Re: *Bunting Multifamily Vacation and Replat, VR-17-009, Review 1 Response*
MVE Project No. 61072

M.V.E., Inc. has prepared the following response to comments contained in your September 20, 2017 comment letter concerning the above named project. Revised submittal materials are enclosed as needed. Each comment is addressed below in the order contained in your comment letter.

AS PLATTED
SCALE: 1"= 30'

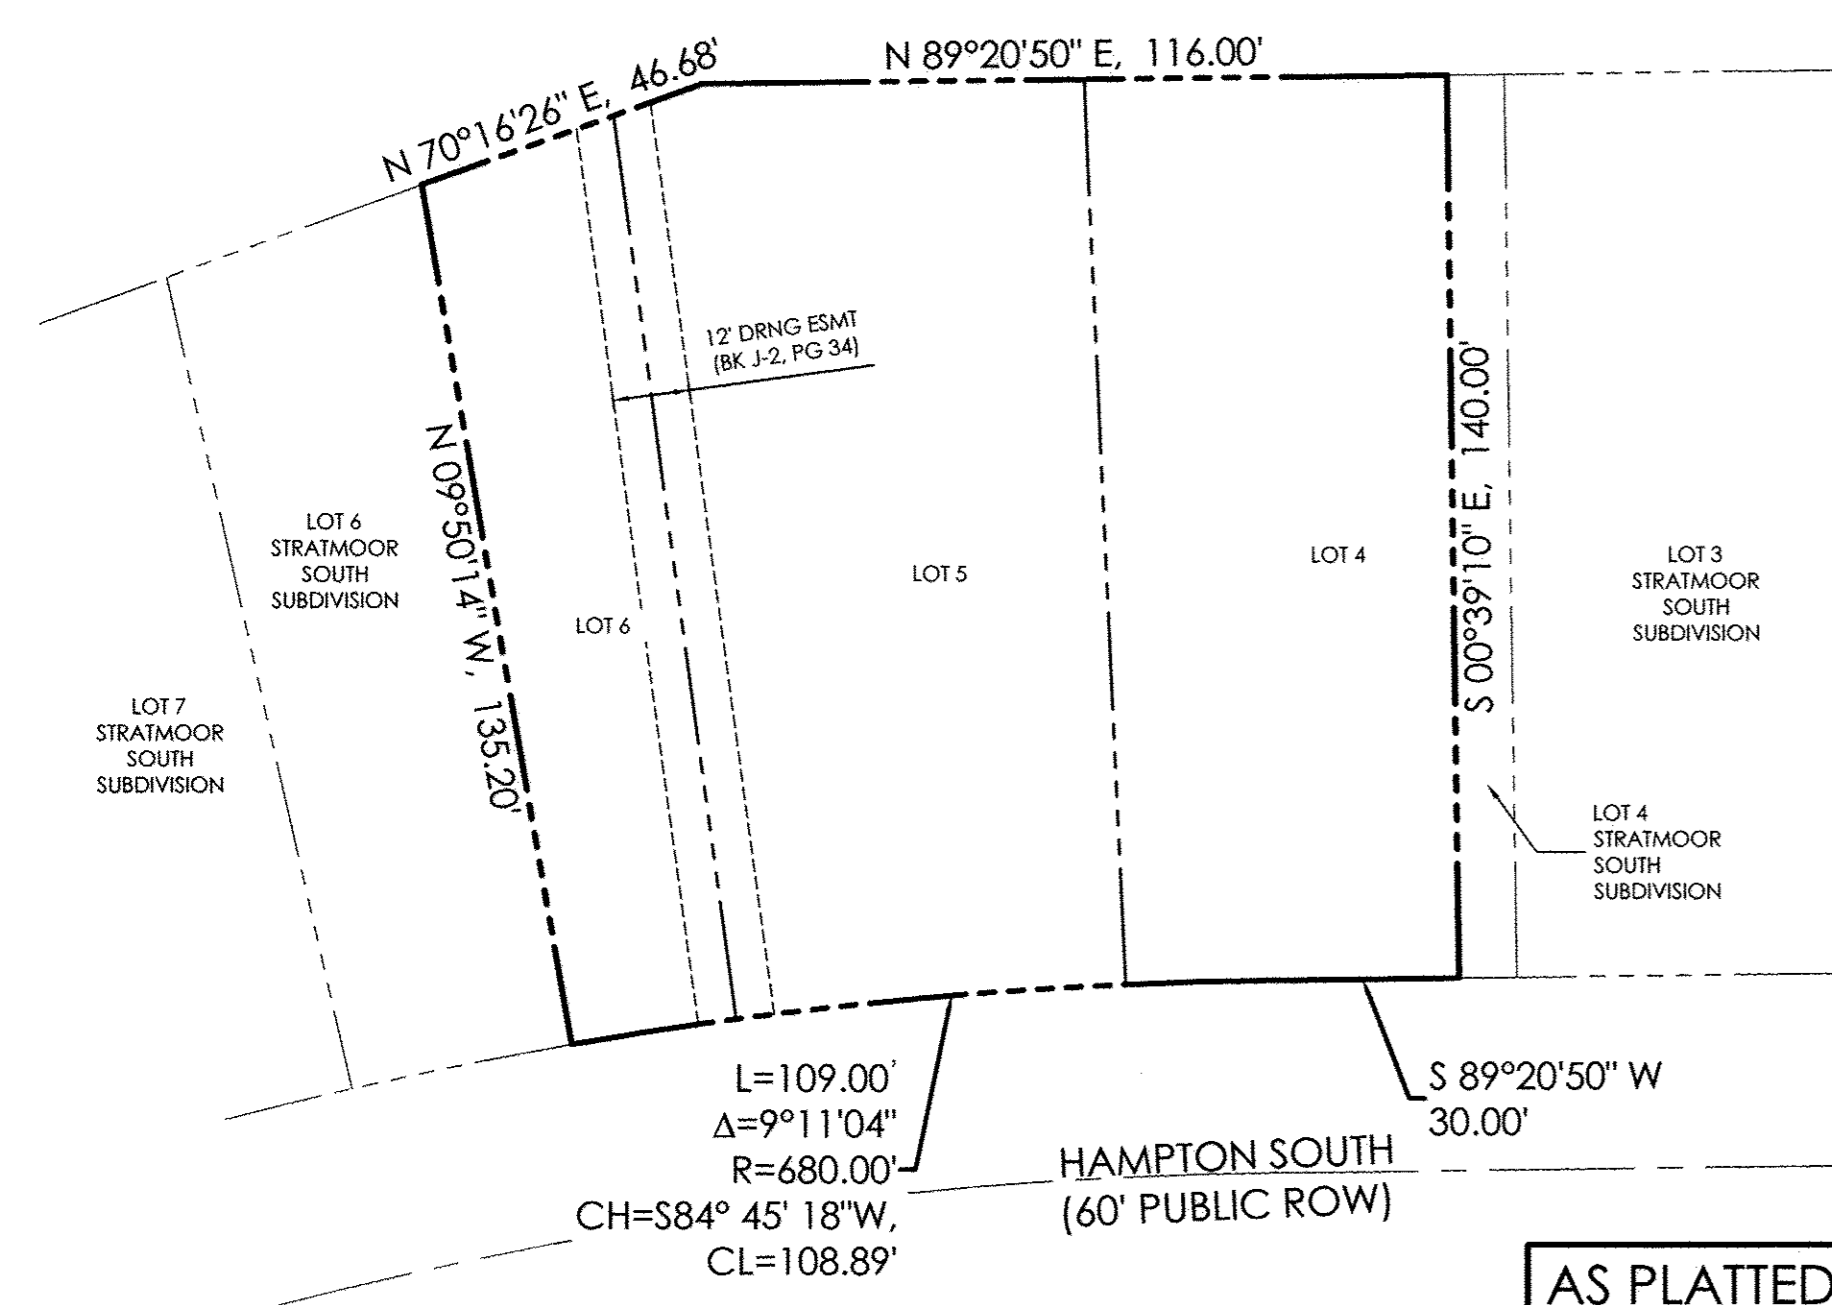
1. *You do not show any found monumentation. Is this correct? Review and revise as necessary.* **Response: All found Monumentation has been added.**
2. *Our data shows underground electric running east/west across these lots on the north side. Please verify and add easement if correct. We also show a private wastewater main running north/south through lot 2 for your information.* **Response: The easement for the electric line is already shown on the plat. The Stratmoor Hill sanitary sewer is accounted for on the plat.**

3. *I see a north arrow on the vicinity map but we also need one on the as platted and as replatted drawings.* **Response: North arrows added.**
4. *Add the following note to the General Notes on the cover sheet: All easements that are dedicated hereon for public utility purposes related to gas and electric shall be subject to those terms and conditions as specified in the instrument recorded at Reception Number 212112548 of the records of El Paso County, Colorado. All other easements or interests of record affecting any of the platted property depicted hereon shall not be affected and shall remain in full force and effect.* **Response: Note added.**
